Subject: Little Beechfield, Dukes Road, Fontwell, Arundel, West Sussex, BN18 0SP - AL/39/21/PL

Planning Application Reference: AL/39/21/PL

Proposal: Installation of a 40ft (12m) container housing an autofeed Biomass Boiler and associated equipment to replace existing boiler and installation of a 20ft (6m) container housing plant room for blown air for existing log drying business. This application is in CIL Zone 3 (zero rated) as other development.

Please see comments below from Environmental Health.

Container for autofeed boiler 1:100

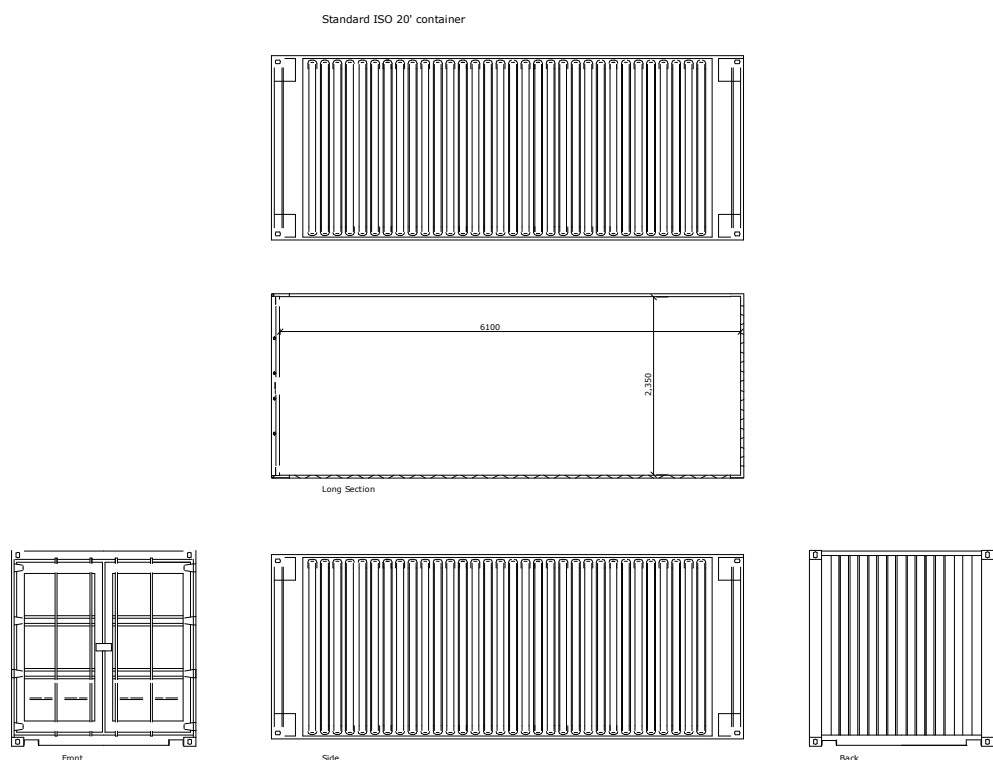
--Further information is required relating to the capacity of the proposed Biomass burner to enable this department to make an informed comment.--

Further information is therefore required to clarify the following:

- The predicted rated thermal input
- Whether the boiler is burning waste or waste-derived biomass
- If the boiler is burning waste or waste-derived biomass, please confirm the hourly aggregate capacity

SOUND SOURCE	OBJECT DESCRIPTION	SOUND LEVEL AT PART	SOUND LEVEL AT r=1.00m	SOUND LEVEL AT r=2.00m
	Primary Blower	-	62 - 66 dBA	60 - 64 dBA
	Flue Gas Blower	-	64 dBA	62 dBA
	Flue	66 dBA	64 dBA	62 dBA

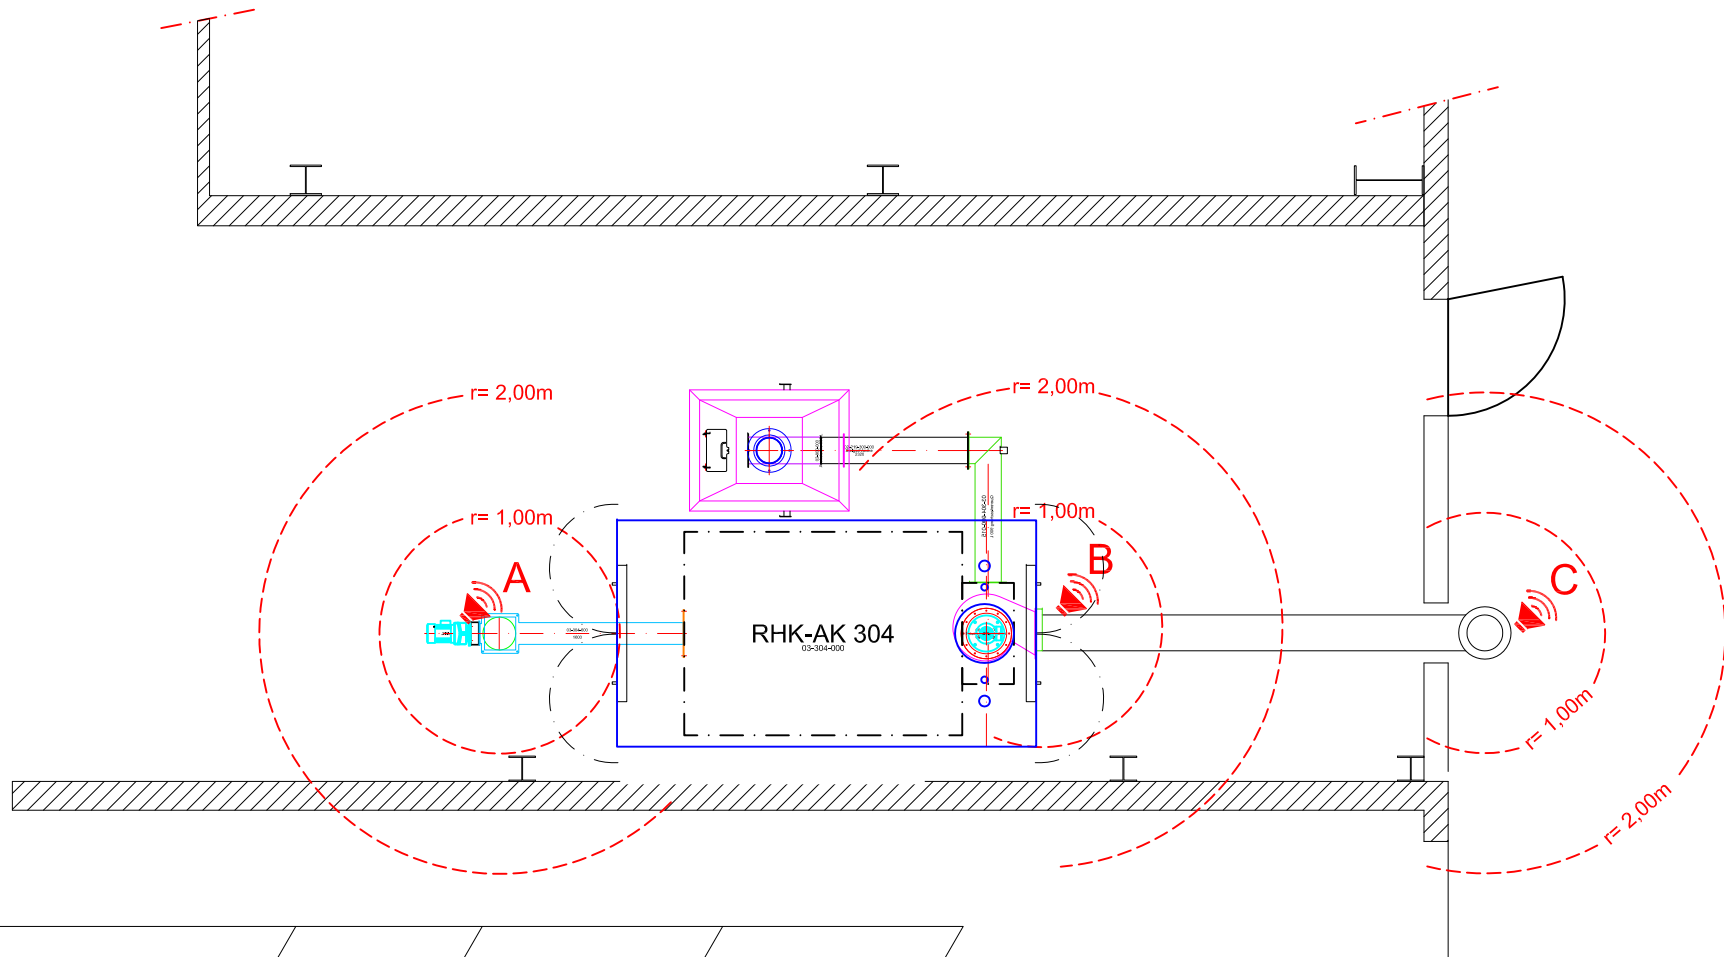
Noise

No development hereby permitted shall commence until an acoustic assessment has been undertaken to determine the impact of noise arising from the development site and the results of the assessment and details of any mitigation measures submitted and approved in writing by the Local Planning Authority. Noise from commercial premises should be controlled, such that the noise rating level ($L_{A_{r,T}}$) emitted from the development does not exceed the background noise level ($L_{A_{90,T}}$), by more than 3dB. All measurements shall be defined and derived in accordance with BS 4142:2014. The approved measures shall be implemented before the development is brought into use and thereafter be maintained in accordance with the approved details.
